# EAGLE RISING FILING NO. 1

A PORTION OF THE EAST HALF (E1/2) OF SECTION 29, TOWNSHIP 12 SOUTH, RANGE 65 WEST OF THE SIXTH PRINCIPAL MERIDIAN, EL PASO COUNTY, COLORADO

EAGLE RISING FILING NO. 1  
FINAL PLAT  
JOB NO. 43-043  
DATE PREPARED: 06/30/2022 DATE REVISION: 11/20/2023  
DATE REVISION: 01/31/2023 DATE REVISION: 03/14/2023  
DATE REVISION: 07/17/2023 DATE REVISION: 08/28/2023  
PCD FIL. NO. SF-22-25

SHEET 2 OF 5

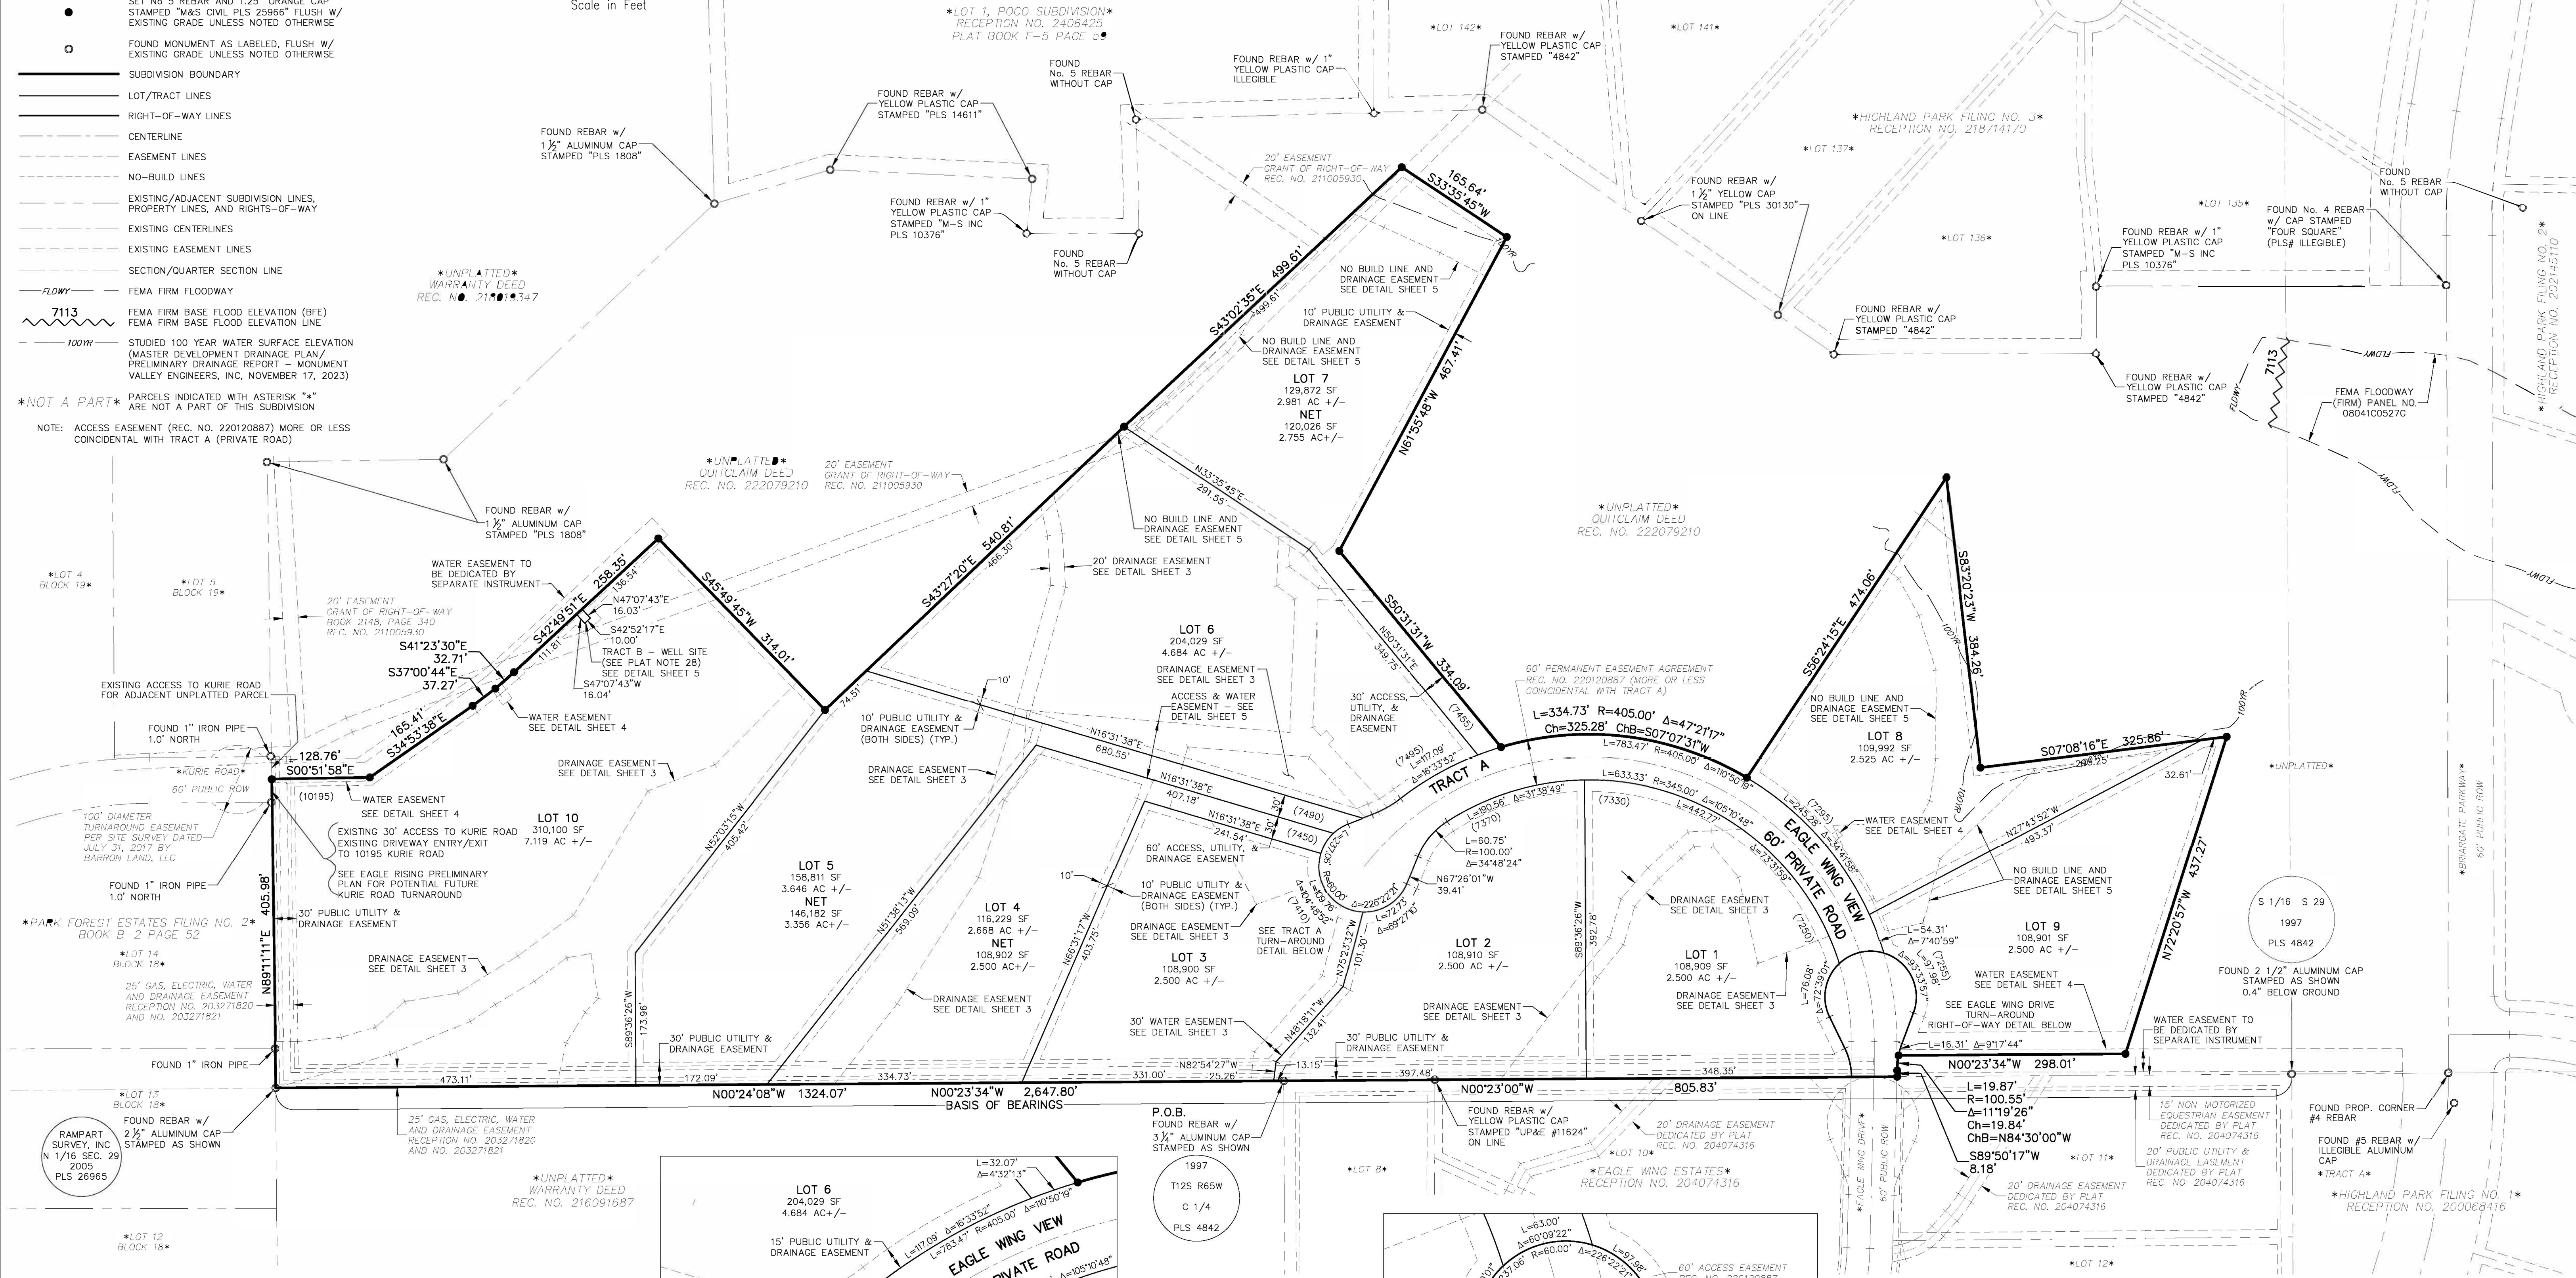
**Cul-de-sac ROW needs to be shown per V3 Plat comments.**

**Right-of-Way Dedication Required. Roads shall be located within a dedicated public right-of-way meeting the requirements of the ECM for the roadway classification proposed. ... In accordance with BoCC policy, the BoCC may allow a disclosure such as "public ROW easement" or "future ROW" to be placed on a plat as an alternative to dedication. If you choose to not provide ROW at this time, and are requesting to instead add a note to call out "public ROW easement" or "future ROW", please add to your LOI to allow the BoCC to make this allowance, also add this call out and the easement area to the plat. A "NEPE" easement document will be required if this option is allowed by the BoCC.**

**This note is not adequate per LDC Sec. 8.4.4.B which states that either public ROW is dedicated, or land for public ROW is preserved. You must depict the land for dedication or preservation for future ROW, per the discussion staff had with the applicant.**

**Please provide copy of a construction easement for future emplacement of pipe and outfall F. Note that Staff is reviewing the drainage "permission" letter sent separately to confirm if that is adequate in place of an actual drainage easement. Reference DCM Section 4.8.1, LDC Sections 6.3.5(B)(2) and 8.4.5(G)(2).**
